**From:** [Holly Duncan](#)  
**To:** [Jeff Watson](#)  
**Subject:** RE: BL-10-00031 Lohnes  
**Date:** Monday, July 26, 2010 10:25:32 AM

**From:** Jeff Watson  
**Sent:** Wednesday, July 21, 2010 4:27 PM  
**To:** Christina Wollman; Brenda Larsen; Jan Ollivier; Holly Duncan  
**Subject:** BL-10-00031 Lohnes

BOUNDARY LINE ADJUSTMENT

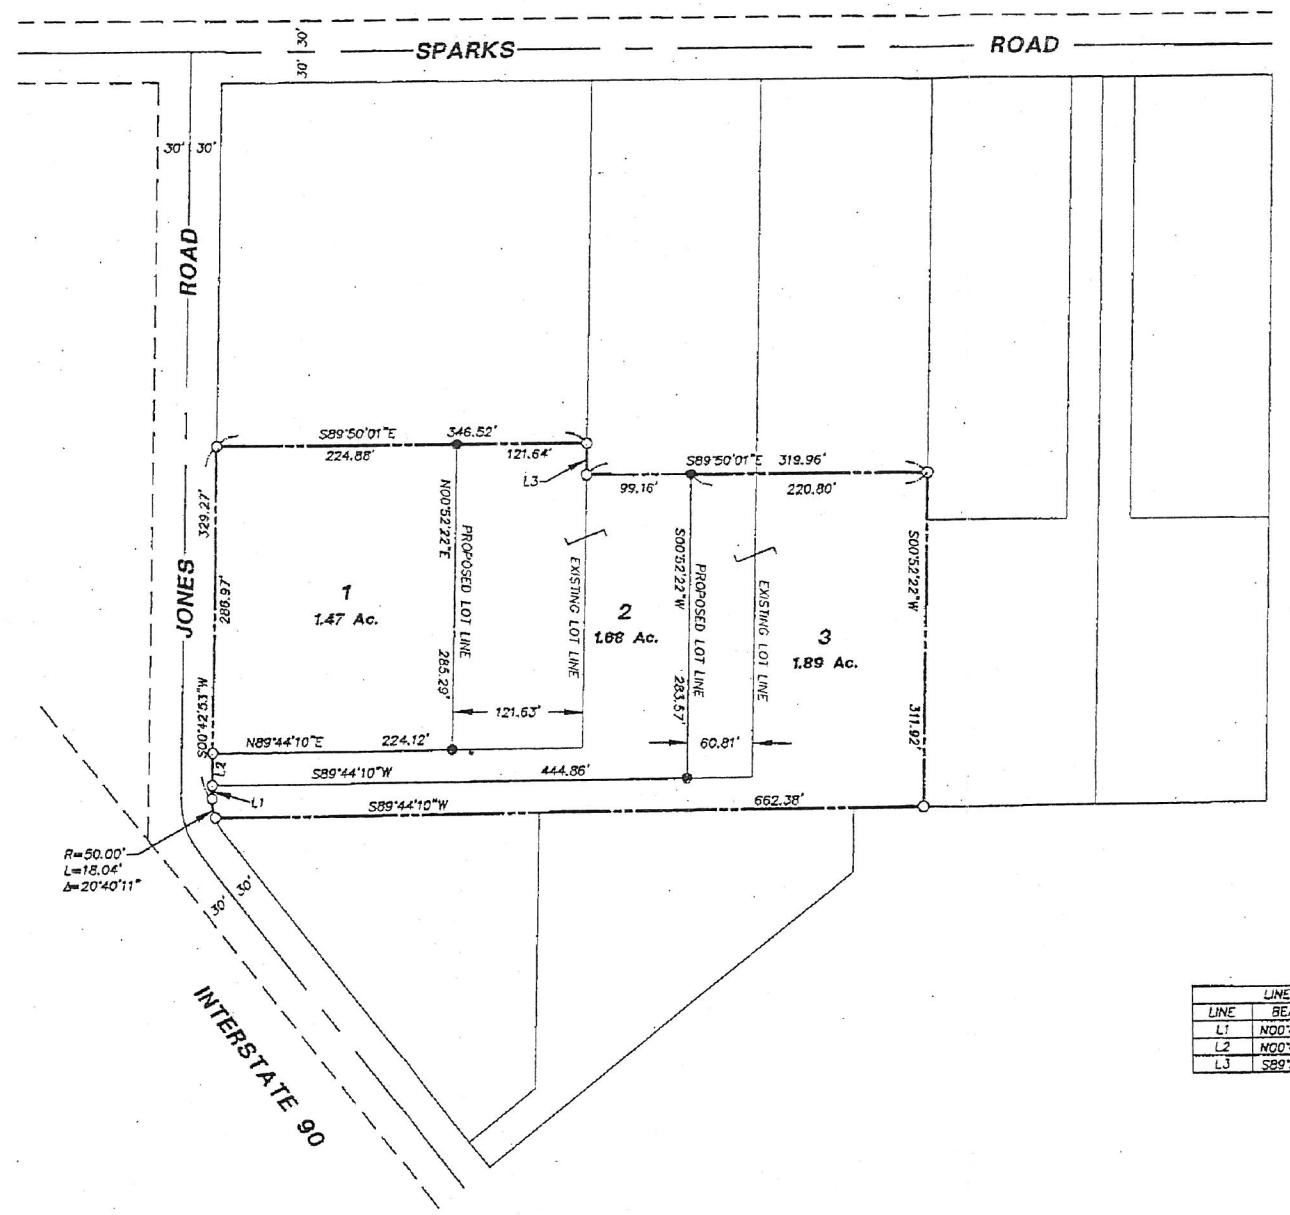
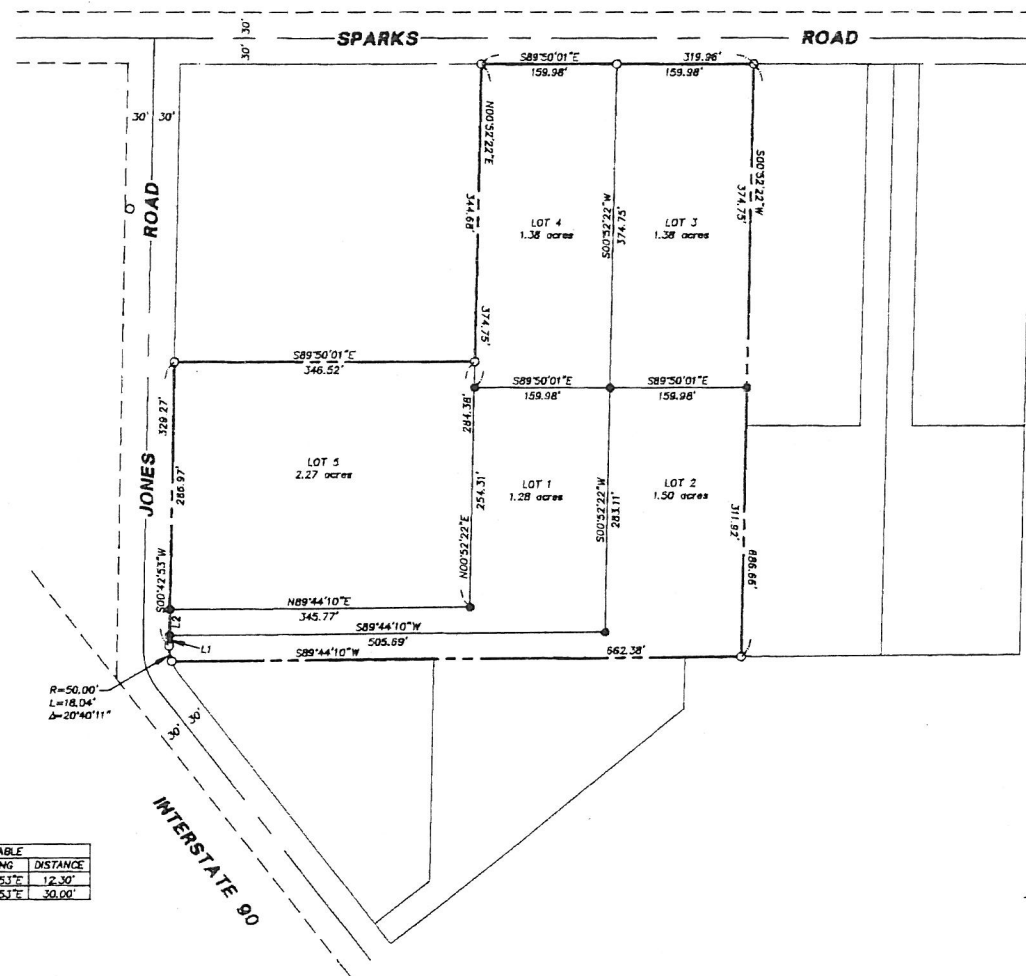
Proposed property lines must be 50 feet from the well.
